The Planning Inspectorate Yr Arolygiaeth Gynllunio

Application by AQUIND Ltd for the AQUIND Interconnector

The Examining Authority's further written questions

Plate 6 - Proposed ~~banksman locations~~ construction traffic management on Day Lane - will be replaced with full page image when issued as PDF

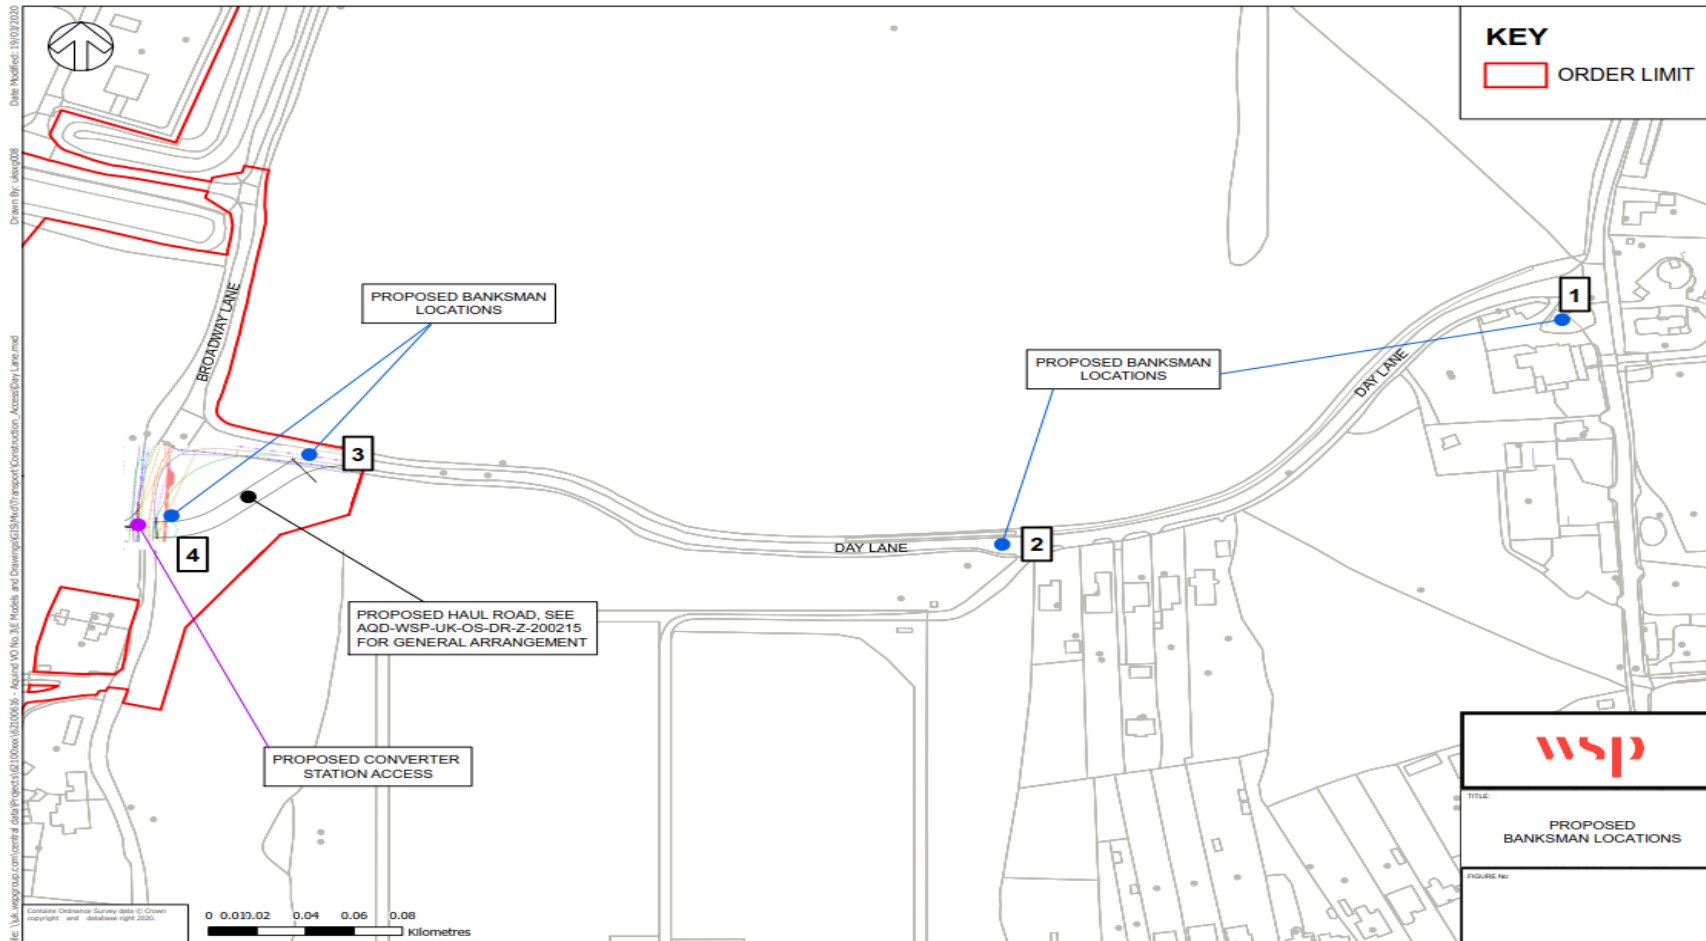
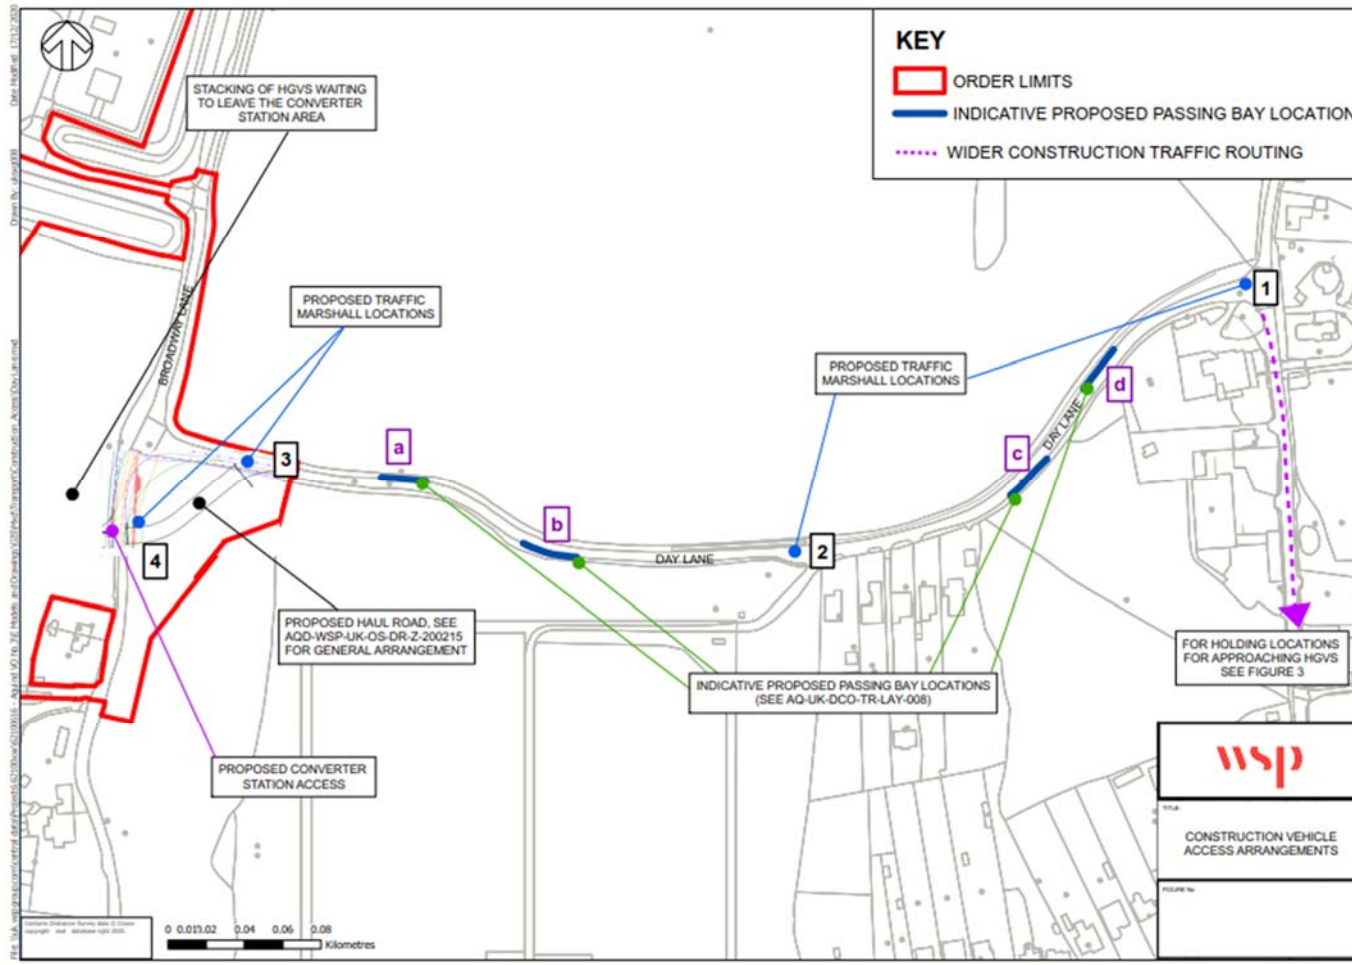
DCO2.5.7	Applicant Hampshire County Council	Please could the ExA be updated on progress towards securing a s278 Agreement with regards to the highway works at the junction of Day Lane and Broadway Lane? Have the technical details been agreed and will the s278 agreement be in place prior to the end of the Examination?
DCO2.5.8	Applicant	For clarity, should Schedule 2, Requirement 15(3) of the dDCO submitted at Deadline 6 [REP6-015] read ' <i>onshore outline construction environmental management plan</i> ' rather than ' <i>outline construction environmental management plan</i> ' in accordance with the definition in Schedule 2(1)? Could a check be made that all such references in the control chart and mitigation schedule are in full, including those to the WSIs?
DCO2.5.9	Applicant NGET	<p>It is noted that the description of Work No.1 in Schedule 1 of the dDCO [REP6-015] has been amended to include works for the extension of the Lovedean substation.</p> <p>Can the Applicant explain the meaning of '<i>site establishment, earthworks, civil and building works</i>'?</p> <p>Does the amended definition meet the needs of NGET and is NGET satisfied that the Applicant's ES covers all likely significant effects?</p>
